Fire Marshal comments  
Swauk Valley Ranch  
SP-25-00010

In future correspondence please refer to:  
Project Tracking Code: **2025-07-04505**  
Property: Kittitas County - Swauk Creek Ranch Development - Conservation Plat  
Re: **Concur with Survey; Follow Inadvertent Discovery Plan**

**TO:** All Staff  
**FROM:** Public Works Plan Review Team  
**DATE:** August 13, 2025  
**SUBJECT:** SP-25-00010 Swauk Valley Ranch

SWAUK VALLEY RANCH CONSERVATION PLAT, SP-25-XXXXX

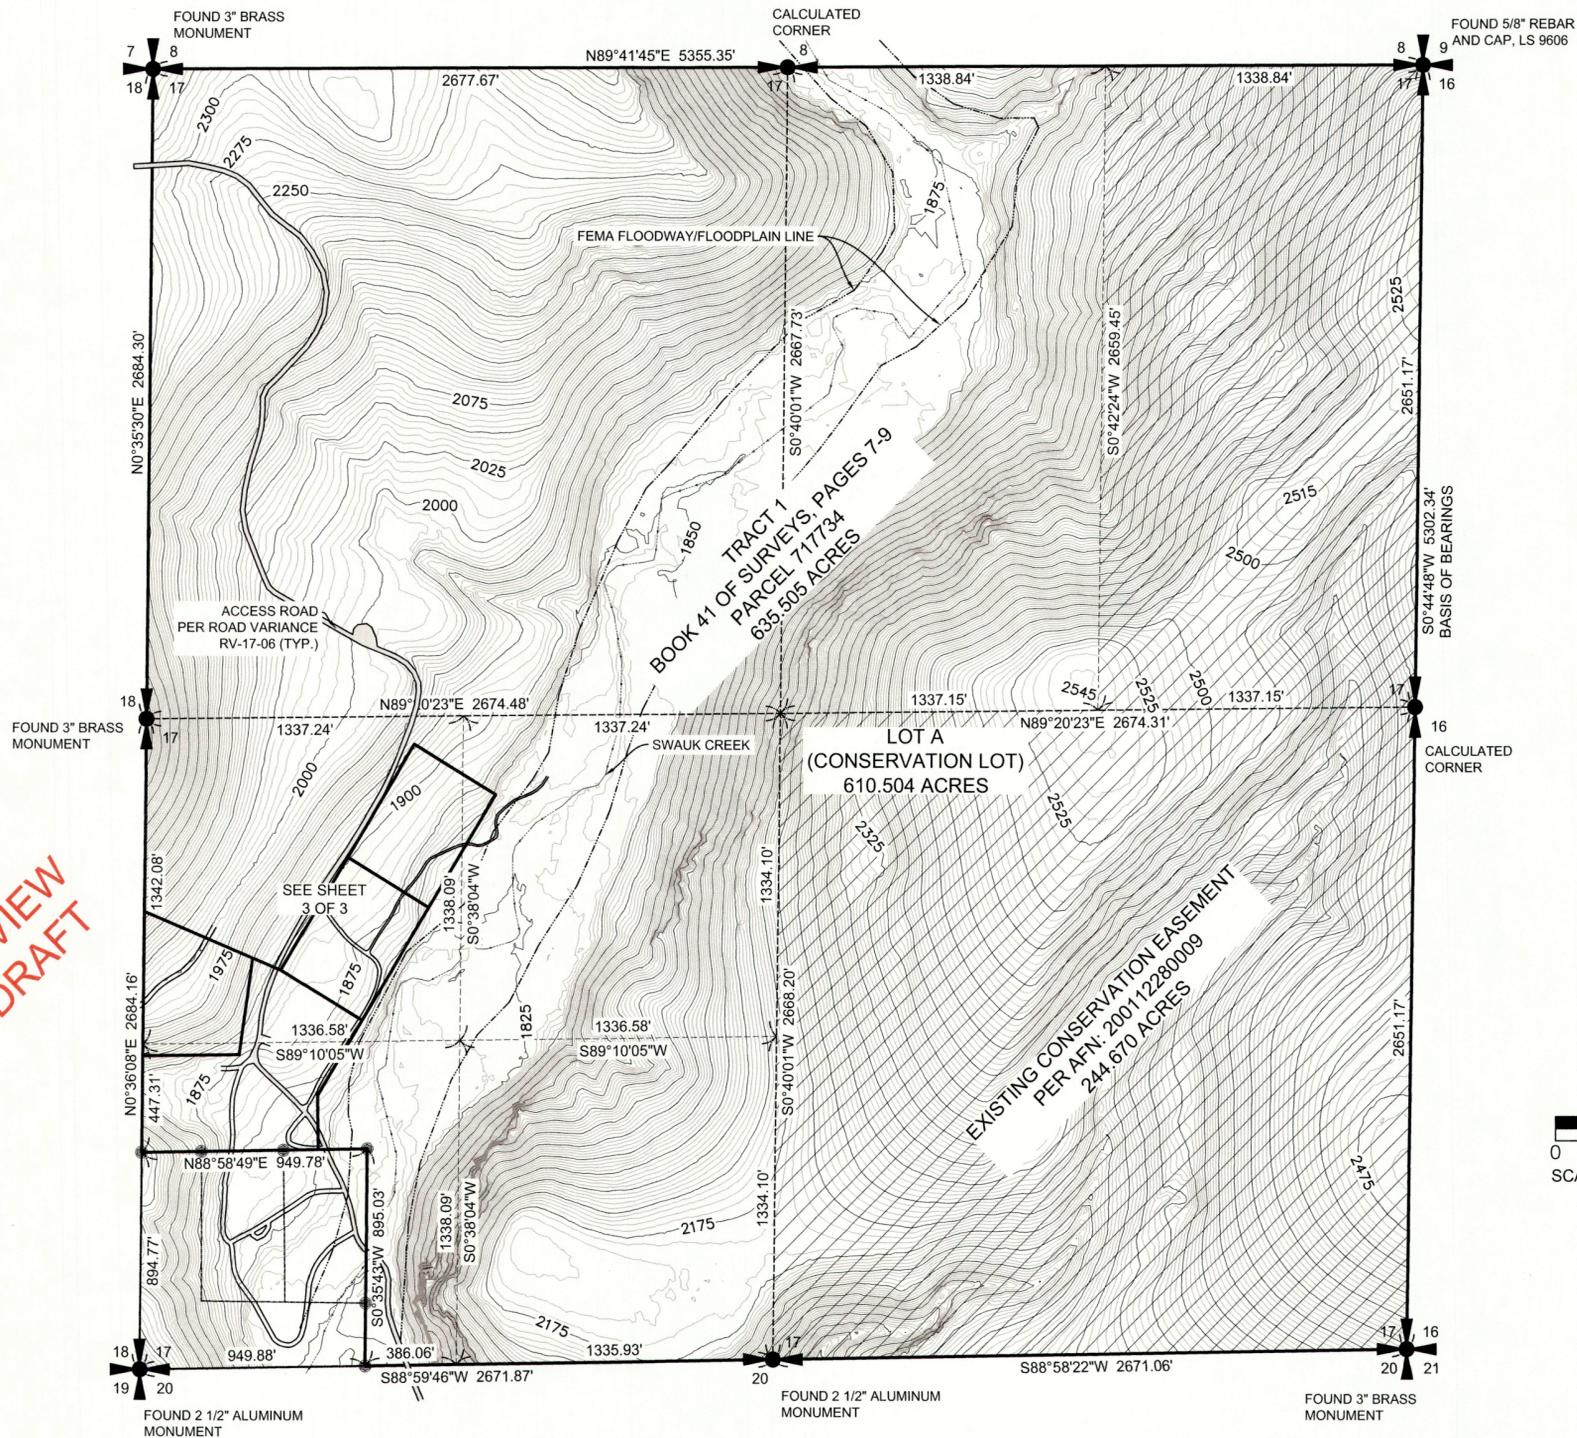
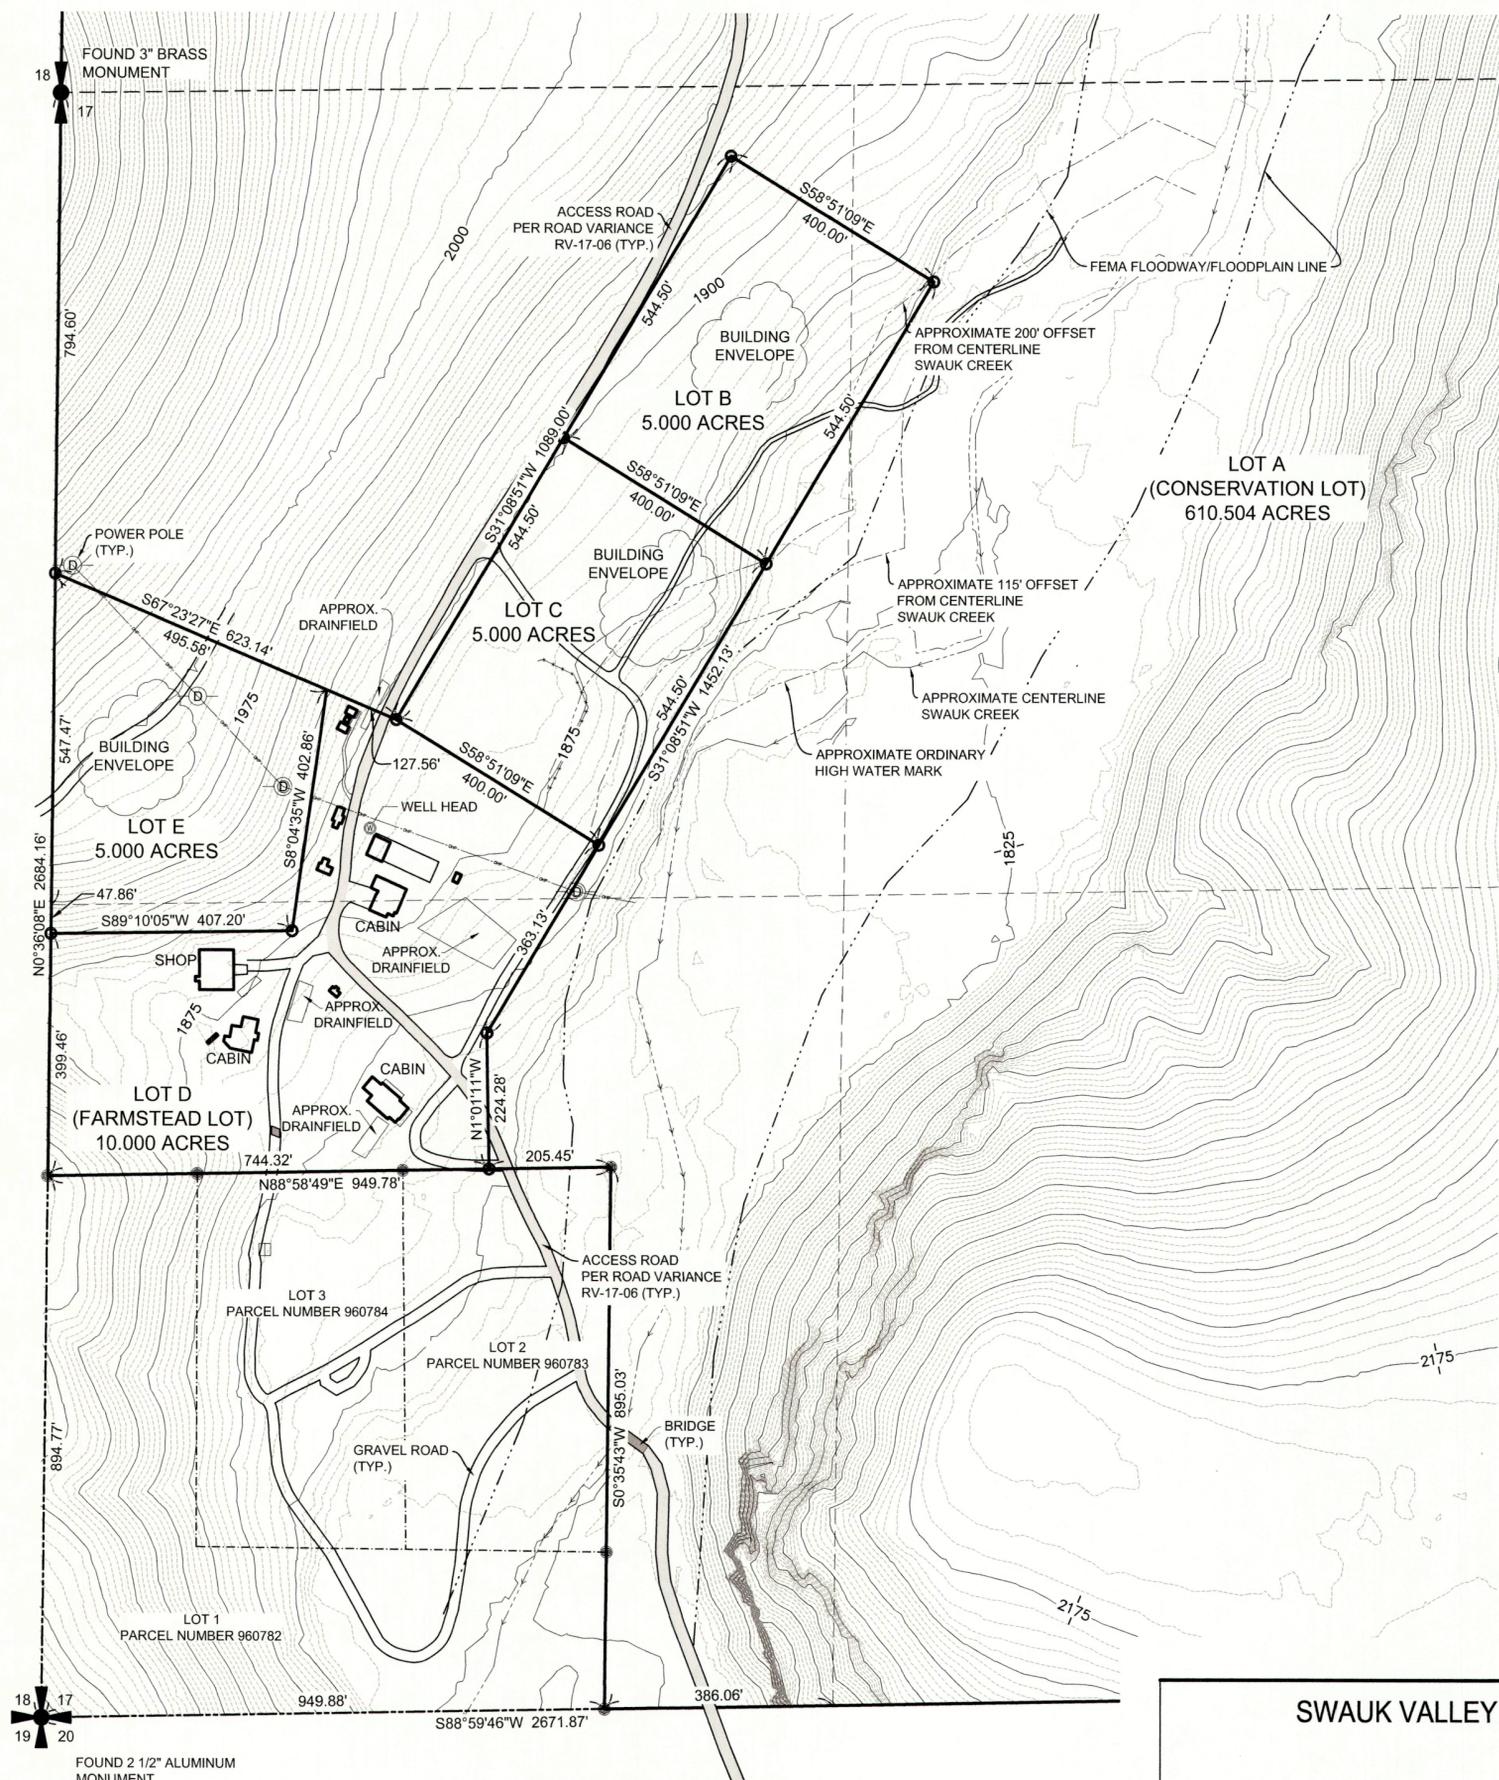
Fire apparatus access is required for this application. The roadways and maneuvering areas as indicated in the application do not adequately provide required fire apparatus access. Provide fire apparatus access roads with an unobstructed width of not less than 20 feet, an unobstructed vertical clearance of not less than 13.5 feet, with an all-weather driving surface and capable of supporting the imposed loads of fire apparatus. Access roads shall extend to within 150 feet of all portions of the facility and all portions of the exterior walls of the first story of the building.

Approved fire apparatus turnarounds are required for this project. The indicated provisions for turning around fire apparatus are not adequate. Provide a turnaround meeting the requirements of the International Fire Code Appendix D.

<b>ENGINEERING</b>	<p>Except as exempted in KCC 14.05.060, no grading or filling upon a site involving more than one hundred (100) cubic yards shall be performed without a grading permit from the County Engineer or Public Works designee (KCC 14.05.050). An application for grading in excess of five hundred (500) cubic yards shall be accompanied by an engineered grading plan (KCC 14.05.080). This grading plan will be under a joint review with the City of Ellensburg. (CBP)</p>
<b>SURVEY</b>	<ol style="list-style-type: none"> <li>1. The pond located approximately 600' North of the N'most corner of Lot B needs to be shown on the face of the map. (Informational only, does not need to be surveyed)</li> <li>2. All new lots, including the remainder parcel need to show access easements.</li> </ol> <p>OF NOTE</p>
